M60/M62/M66 Simister Island Interchange

7.18 Statement of Common Ground with Bury Metropolitan Borough Council

7.6 Statement of Common Ground with Bury Council

Version	Date	Status of Version
P01	15 October 2024	Examination Deadline 2

FIGURE 5.10

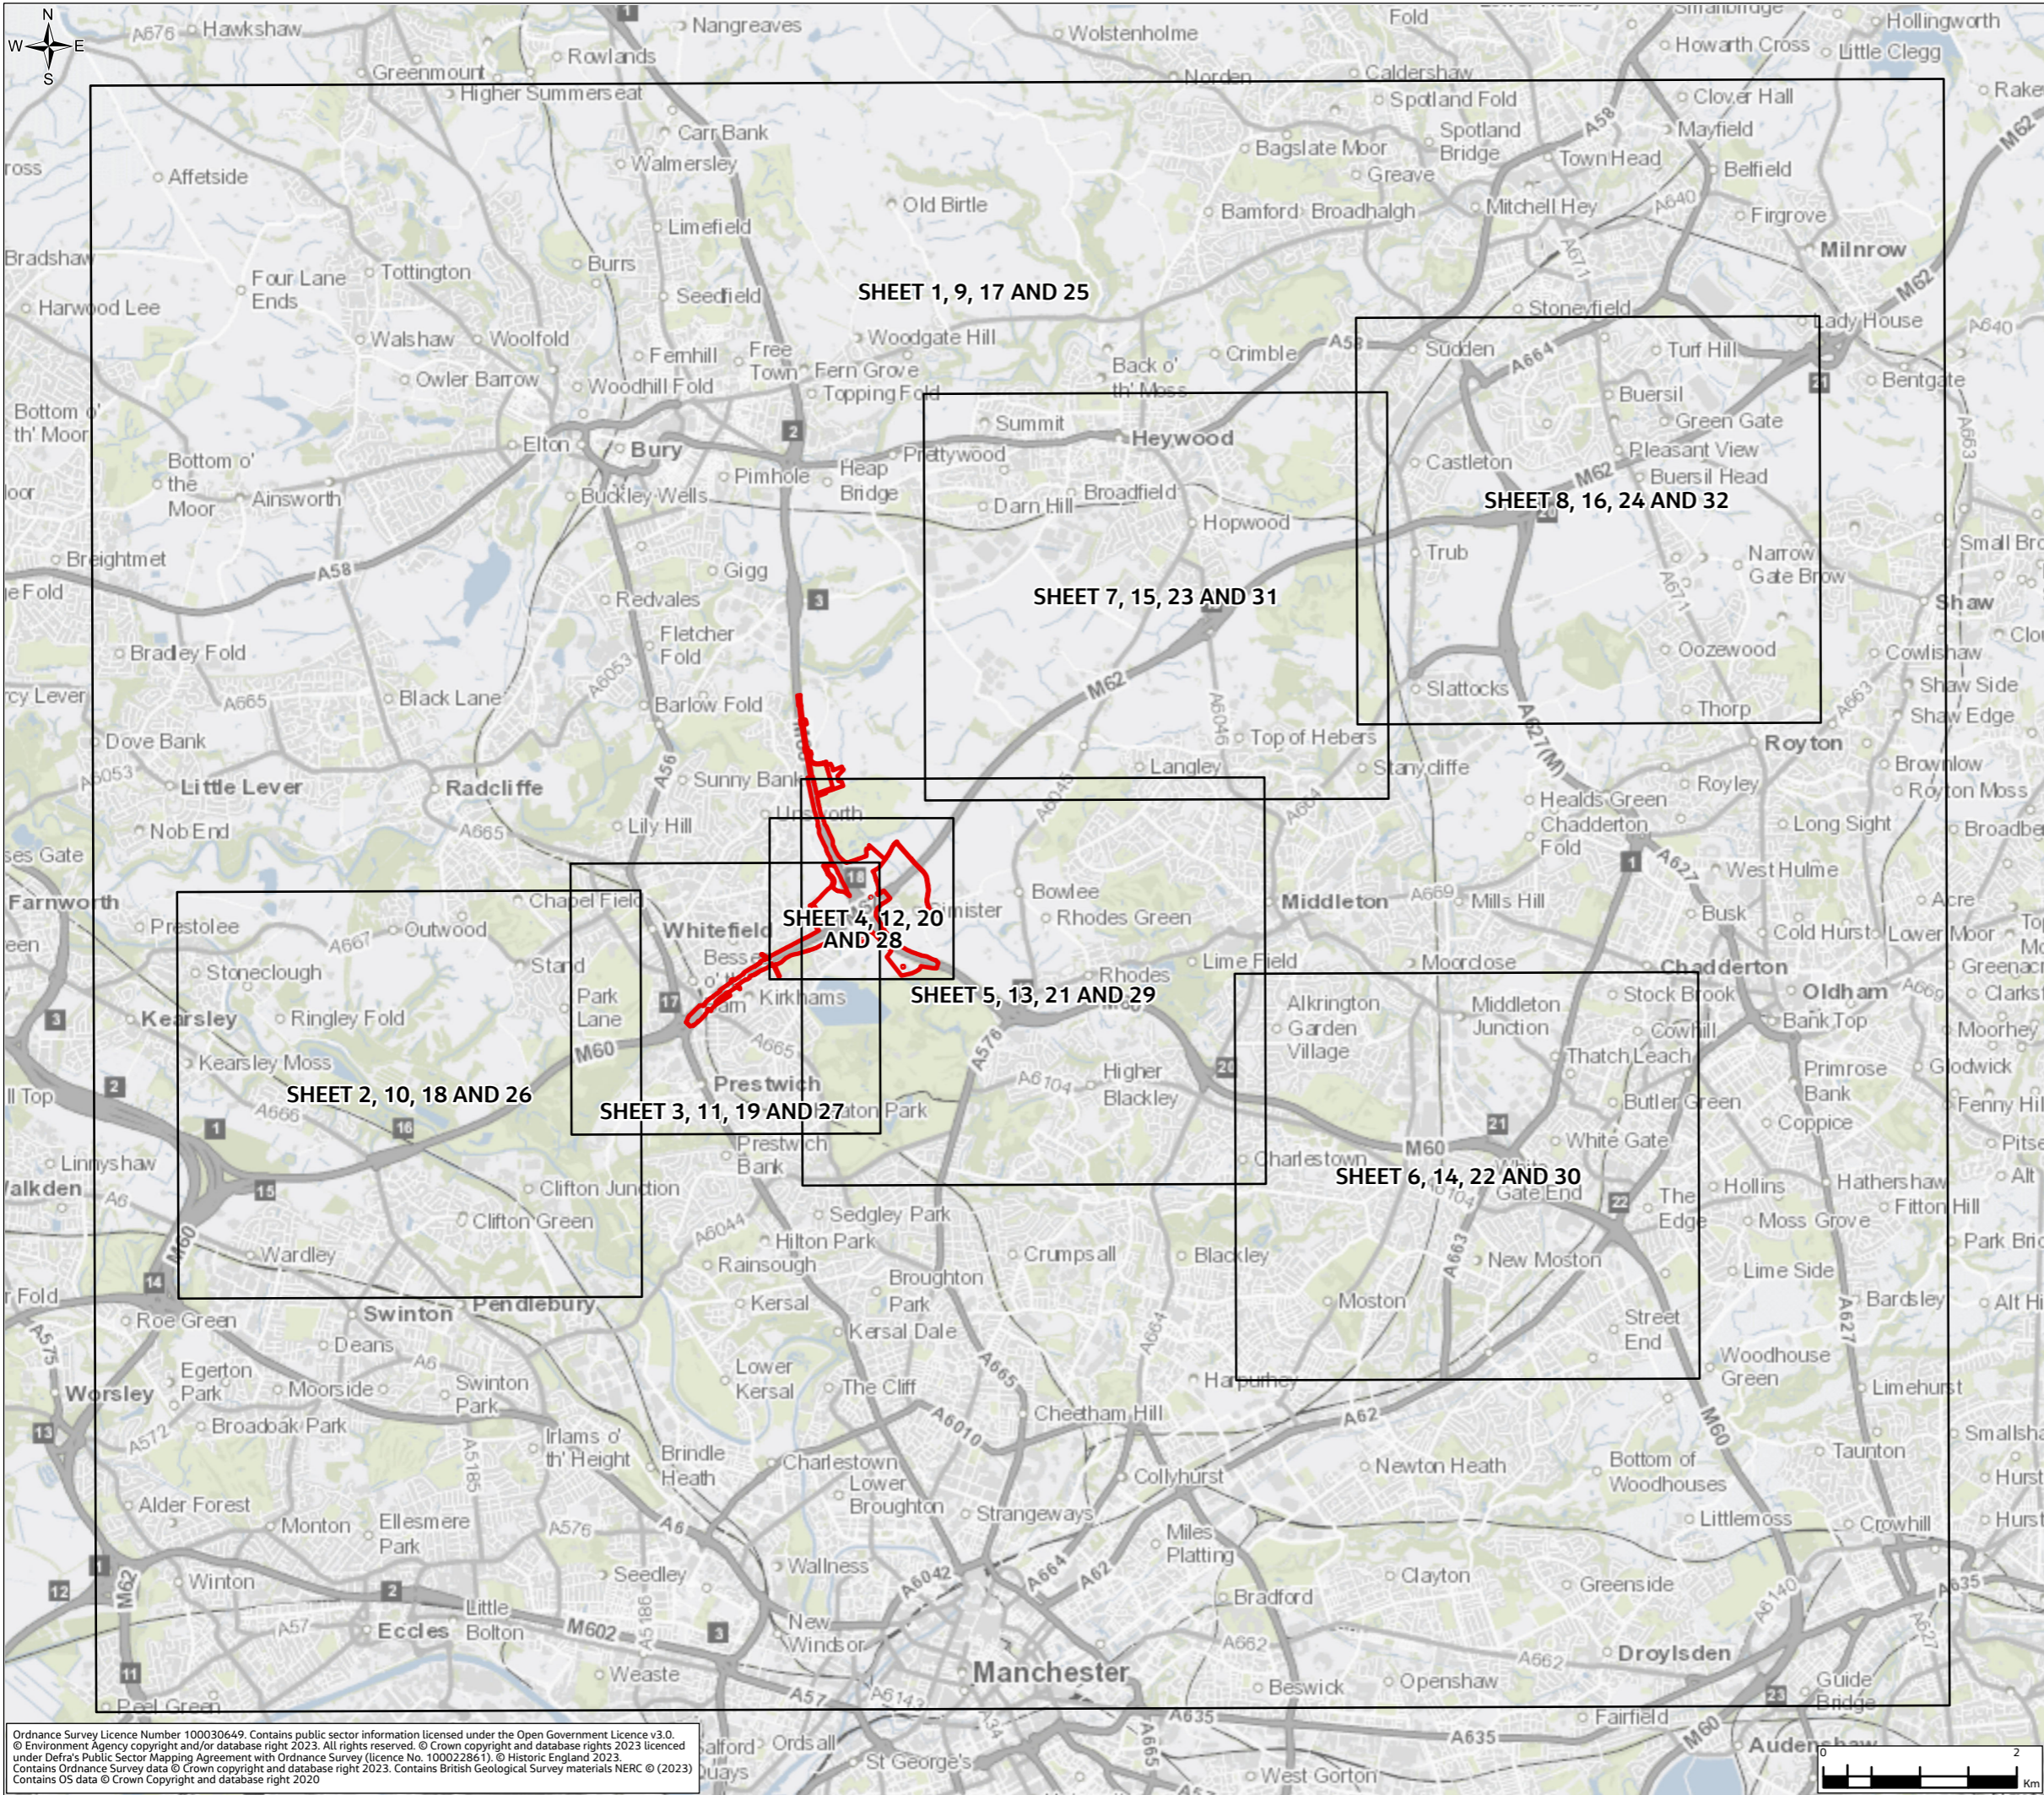
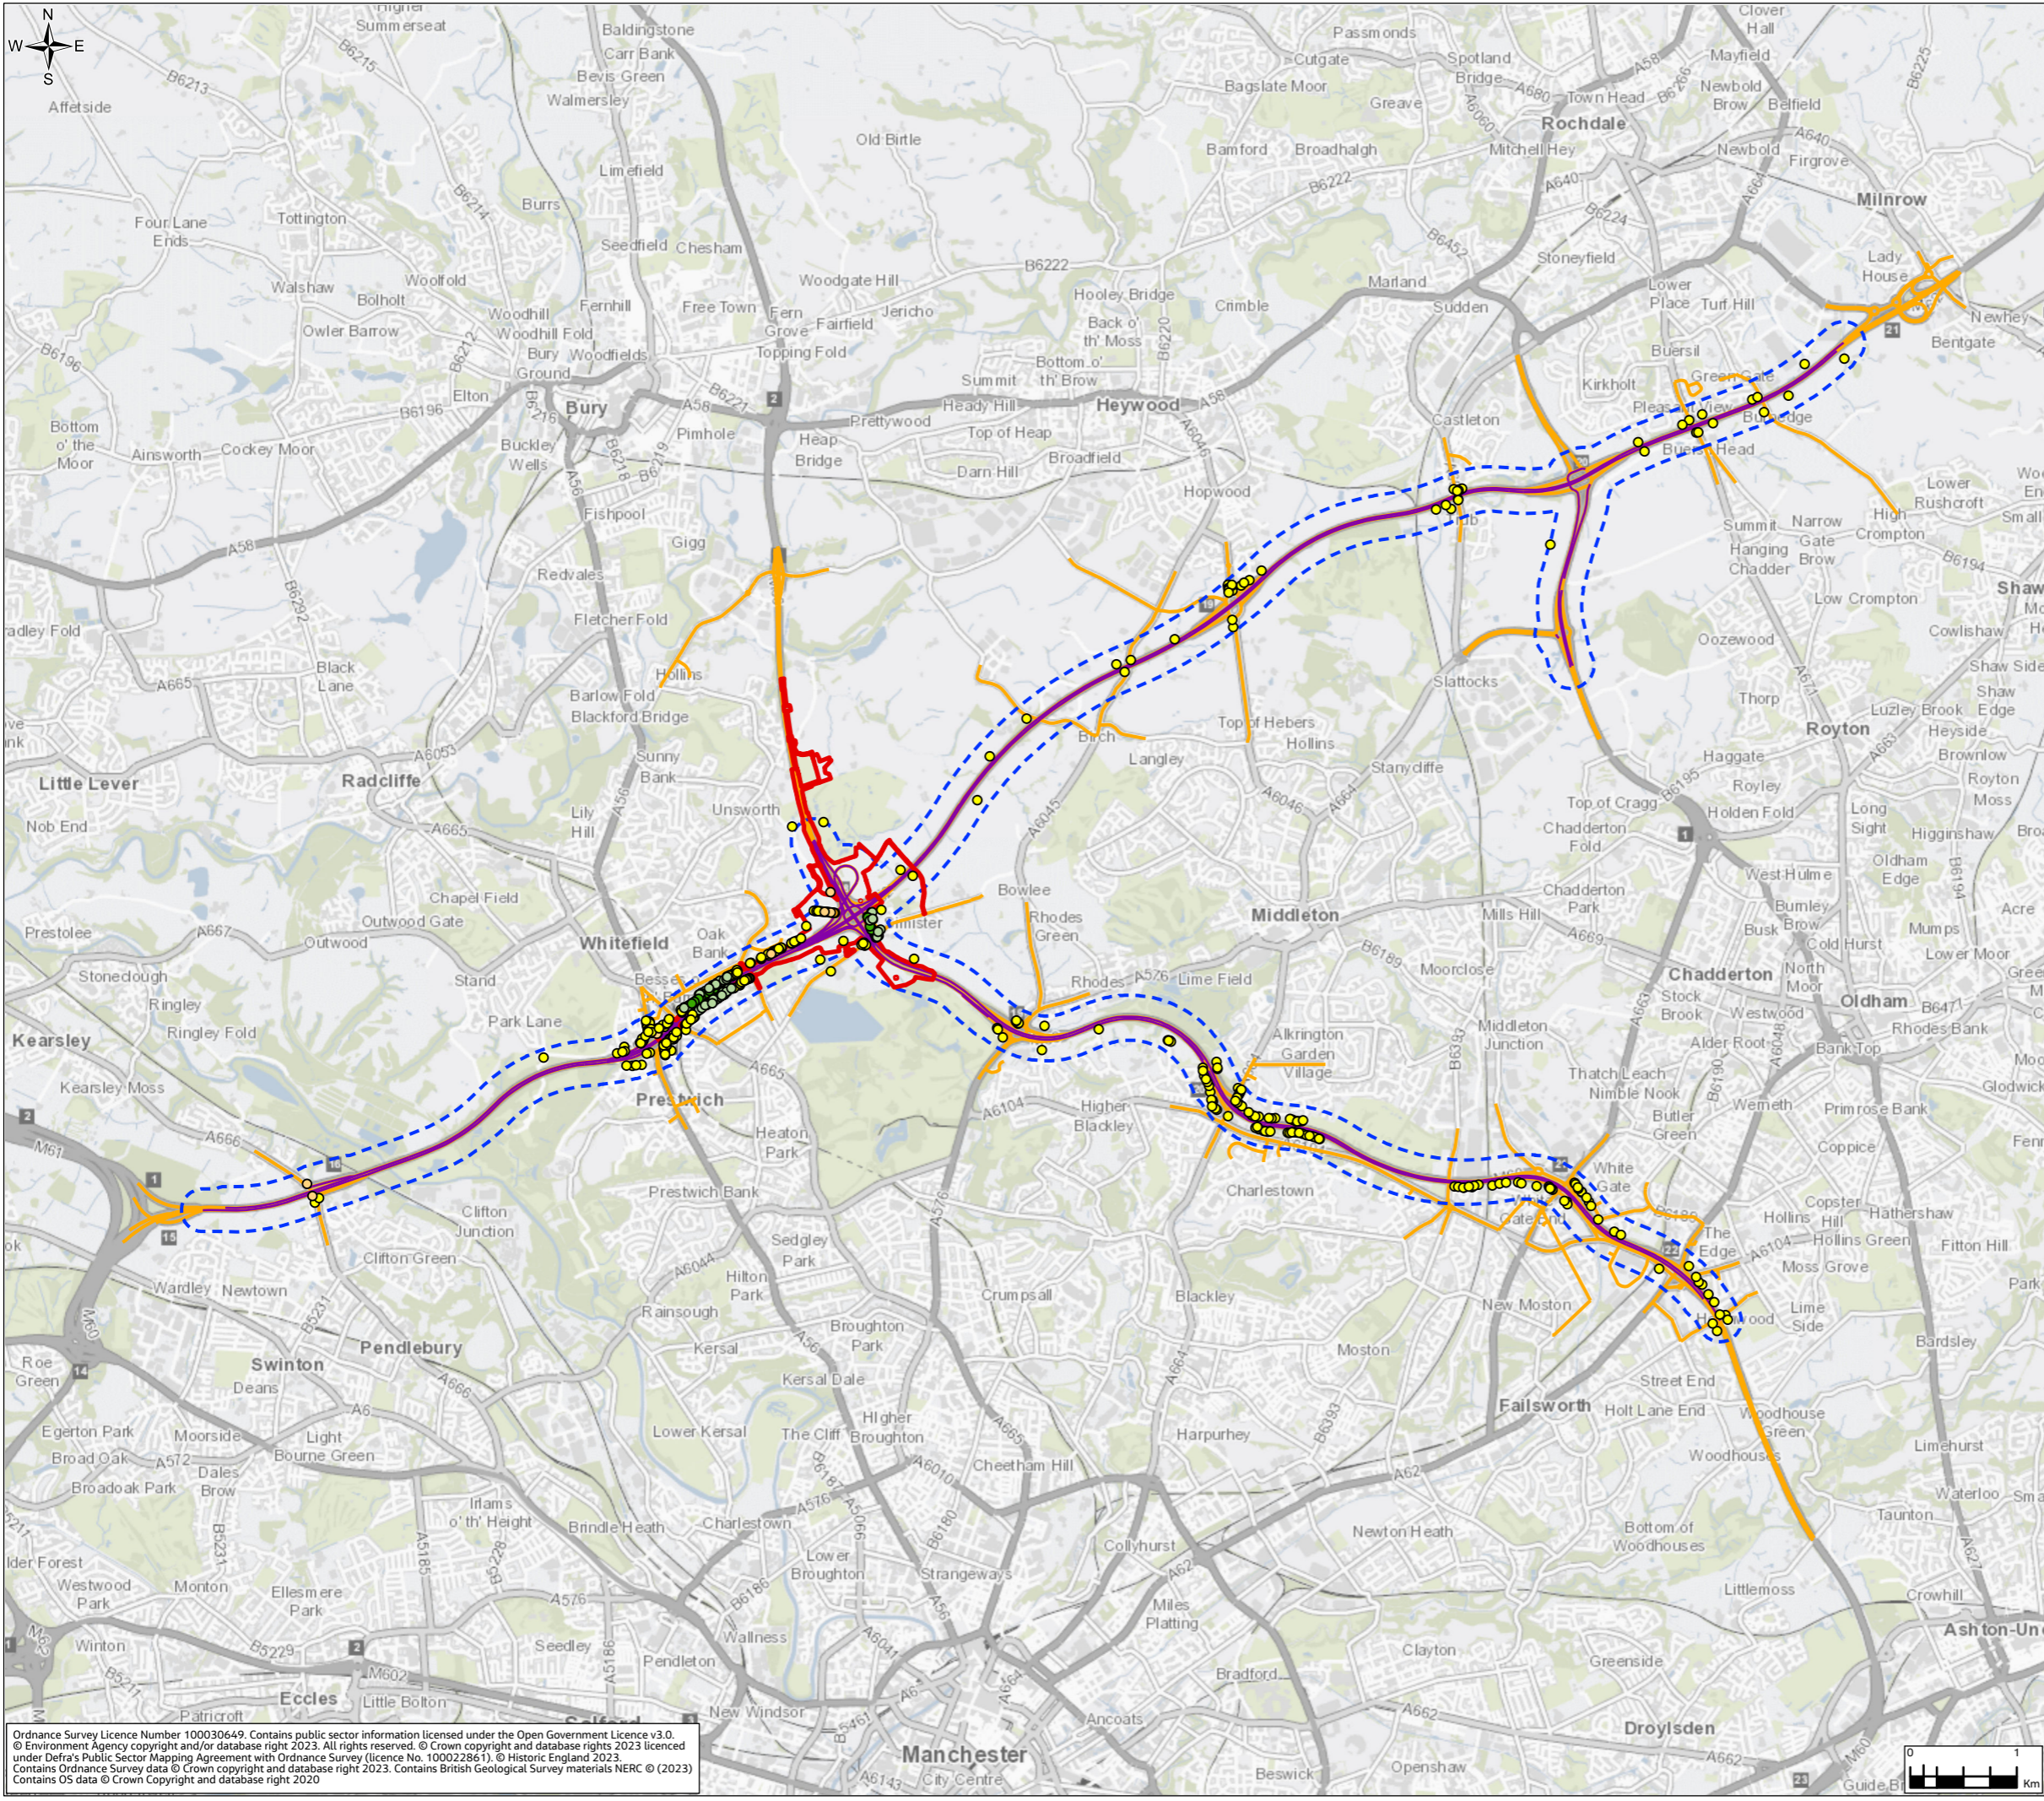
4	Operational Phase Air Quality Impacts	Chapter 5: Air Quality of the Environmental	Bury Metropolitan Borough Council reviewed the results of the operational traffic assessment presented in Appendix 5.2: Air Quality Results [APP-	The Applicant notes Bury Metropolitan Borough Council comments on the findings and conclusions of the	No	Not Agreed	26/09/24

Ref	Issue	Doc Ref	Bury Metropolitan Borough Council Position	National Highways' Position	Agreement Likely	Status	Date
		<p>Statement [APP-045]</p> <p>Appendix 5.2: Air Quality Results [APP-080] of the Environmental Statement Appendices</p> <p>Chapter 5: Air Quality (Figures 5.10-5.11) [APP-061] of the Environmental Statement Figures</p> <p>draft Development Consent Order [REP1-004].</p>	<p>080] of the Environmental Statement Appendices and Chapter 5: Air Quality (Figures 5.10-5.11) [APP-061] of the Environmental Statement Figures. Based on the information provided, the findings and conclusions of the operational phase traffic risk assessment appear reasonable.</p> <p>Bury Metropolitan Borough Council note that the assessment concludes that the operational phase will improve air quality. In order to demonstrate that the predicted improvements in air quality have been achieved, A programme of air quality monitoring (for NO₂) should be undertaken once the Scheme is operational to demonstrate that the predicted improvements in air quality have been achieved.</p> <p>Bury Metropolitan Borough Council notes the Applicant's position that there are no identified significant effects for air quality for the Scheme, as set out in paragraph 5.11.1 of the Chapter 5 Air Quality of the Environmental Statement [APP-044], there is no requirement to undertake future air quality monitoring where the assessment concludes no significant effects.</p> <p>Bury Metropolitan Borough Council also notes that the traffic flow monitoring to be carried out as part of the Post</p>	<p>operational phase traffic risk assessment.</p> <p>Chapter 5 Air Quality of the Environmental Statement [APP-044] discusses the air quality assessment and concludes that there would be no significant effects, due to air quality, during construction and operation of the Scheme from road traffic changes. The assessment of significant effects is based on the Design Manual for Roads and Bridges (DMRB) LA 105 (Air quality) definitions, which are explained in Chapter 5 Air Quality of the Environmental Statement [APP-044]. Closer to the Scheme, between M60 junction 17 and M60 junction 18 and around Simister, there is generally a reduction in air pollution concentrations (i.e., an improvement in air quality) with the Scheme in place. This reduction is due to either reduced congestion between M60 junction 17 and M60 junction 18 or, for Simister, due to traffic using the Northern Loop slip road (i.e., some traffic is moved further away).</p> <p>In response to Bury Metropolitan Borough Council's request for a programme of air quality monitoring, the Applicant notes that some schemes with predicted significant effects in relation to air quality undertake monitoring to</p>

Ref	Issue	Doc Ref	Bury Metropolitan Borough Council Position	National Highways' Position	Agreement Likely	Status	Date
			<p>Opening Project Evaluation (POPE) process to determine whether predicted flow rates were realistic could also be used to assess whether the predicted air quality impacts were accurate. However, we still consider that carrying out a programme of diffusion tube (NOx) monitoring would be a positive action to demonstrate to concerned local residents that local air quality had not been significantly worsened by the Scheme and that the predicted impacts of the Scheme were accurate. It is understood that the Applicant already monitors in certain locations within the vicinity of the motorway network and we do not consider that the extending this diffusion tube monitoring network would be an onerous requirement. This issue is not agreed.</p>	<p>assess compliance against Air Quality Objectives and/or Limit Values. However, as discussed in paragraph 5.11.1 of the Chapter 5 Air Quality of the Environmental Statement [APP-044], as there are no identified significant effects for air quality for the Scheme, there is no requirement to undertake future air quality monitoring. It should be noted that it is very difficult to prove the impact of a scheme, by itself, on air quality by monitoring future air quality. This is due to the typical year-to-year variations that occur due to differing conditions such as wind speed and direction, as well as year to year changes in vehicle emissions, which are changes not related to the Scheme. Typically, the impact on air quality from a scheme is assessed under the Post Opening Project Evaluation (POPE) process, which is undertaken on all major road schemes once it has been operational for one year and again 5 years post-opening. Other schemes under POPE have used monitored road traffic flows and speeds before and after a scheme is opened, to calculate a scheme-only change to emissions which are due to changes in traffic (as opposed to air quality changes due to metrological conditions or changing vehicle emissions).</p>
